Our Ref: R/2023/8/D & D/2016/41/I
File No: 2024/531937

Request for Advice on Modification – Harbourside Podium and Tower MOD 2 – Design Development – SSD-49295711-MOD-2 & Harbourside Shopping Centre Redevelopment Concept – SSD-7874-MOD-4

Thank you for your correspondence dated 2 September 2024 inviting the City of Sydney (the City) to comment on the Request for Advice on Modification in relation to MOD 2 – Design Development for the Harbourside Podium and Tower development, and MOD 4 – Harbourside Shopping Centre Redevelopment Concept at 2-10 Darling Drive, Sydney.

Public Domain Impacts – paragraph 24

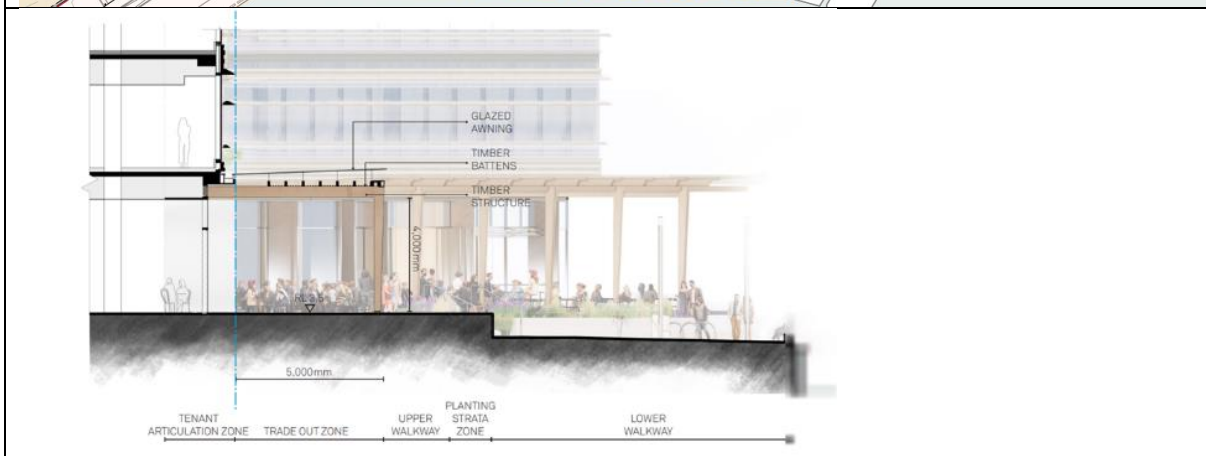
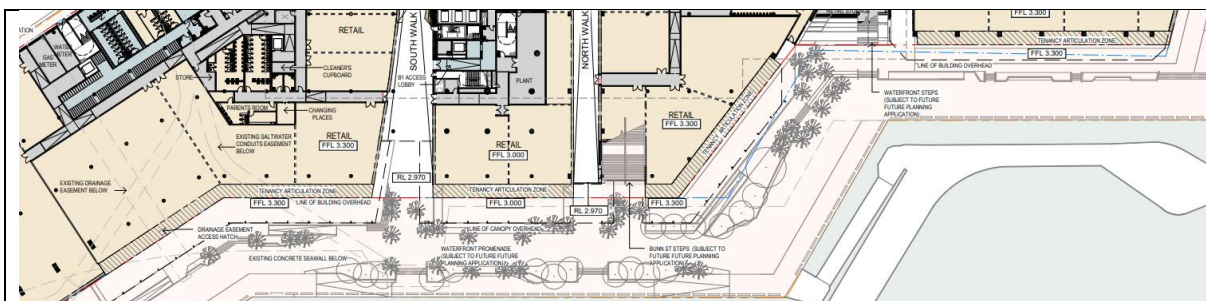
The proposal removes the 'grand' stair and replaces it with the Bunn Street steps at the western end of the north walk. The previous 'grand' stair connected with each floor level as it ascended and potentially could be delivered at a civic grade. The proposed Bunn Street steps does not provide a connection to each level as it ascends as it sits within a void and due to its configuration, is unlikely to be provided at a civic grade.

The Bunn Street through site link is approx. 6m wide. Previous submissions show a 'grand' stair and north walk with a combined width of approx. 14m. The 'grand' stair connected with each floor level as it ascended and would assist in pedestrian flows to

the event and conference uses. The proposed Bunn Street steps does not provide a connection at each level and is 1.6m wide, which is sufficient for two people to pass but not an adult holding a child's hand in both directions.

If the reconfiguration of the stair is approved, the City recommends:

- An additional Bunn Street lift is to be provided to cater for pedestrians of all walking abilities. The lift servicing of the Bunn Street pedestrian bridge has not been detailed in the Accessibility Statement. It is also noted that the jury comments stated: Lifts should be co-located with the public stair or have clear visibility from the public domain.
- The DIP comments be adopted as conditions of consent, including that there be no outdoor seating permitted within the north walk for tenancies.

Figure 1 – Ground Floor Retail Layout

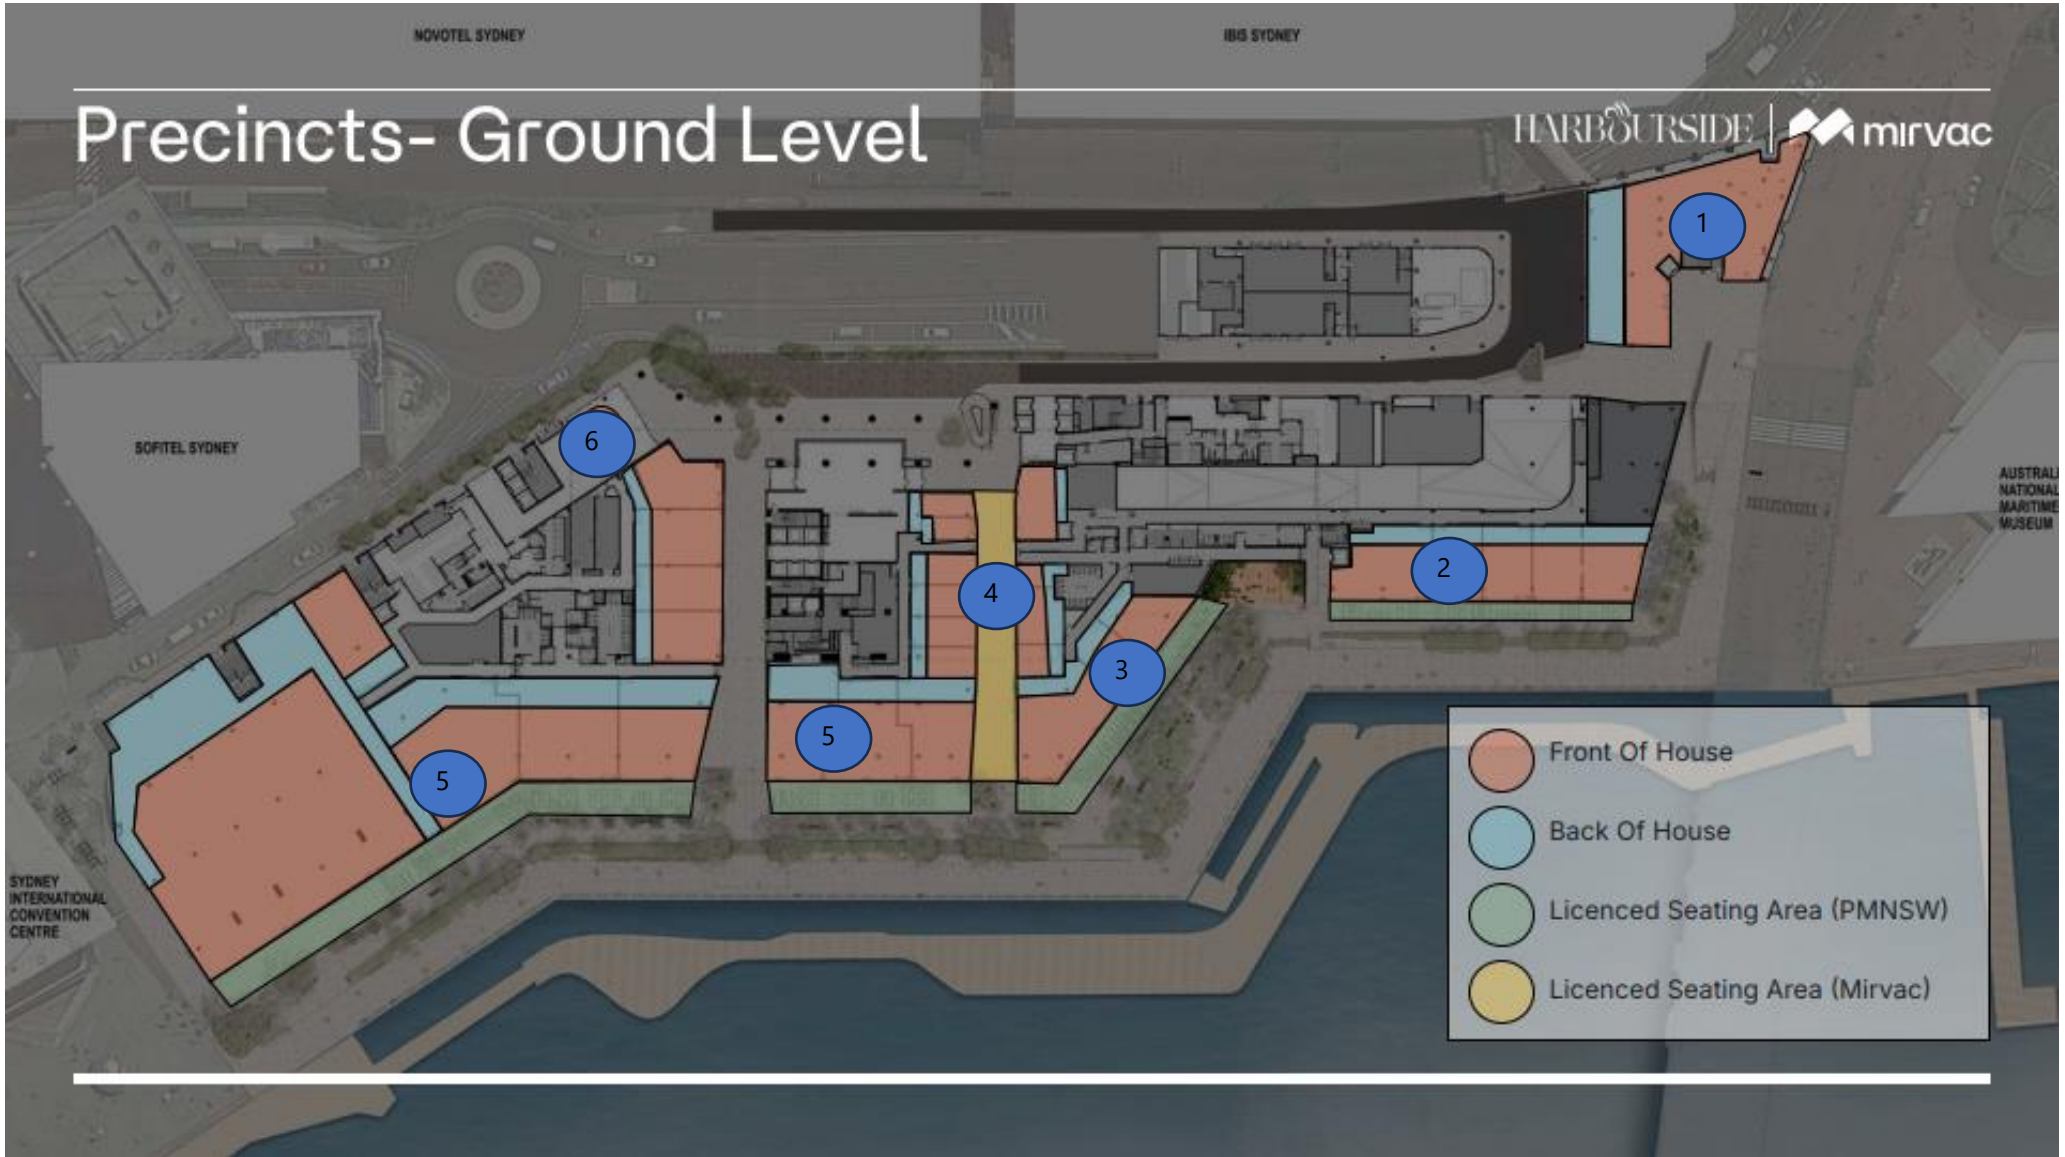
No outdoor seating associated with the tenancies is shown in the ground level plan. No built-in furniture has been shown in the architectural drawings nor in the design report. The City recommends that it be conditioned that no outdoor seating for tenancies is permitted within the north walk.
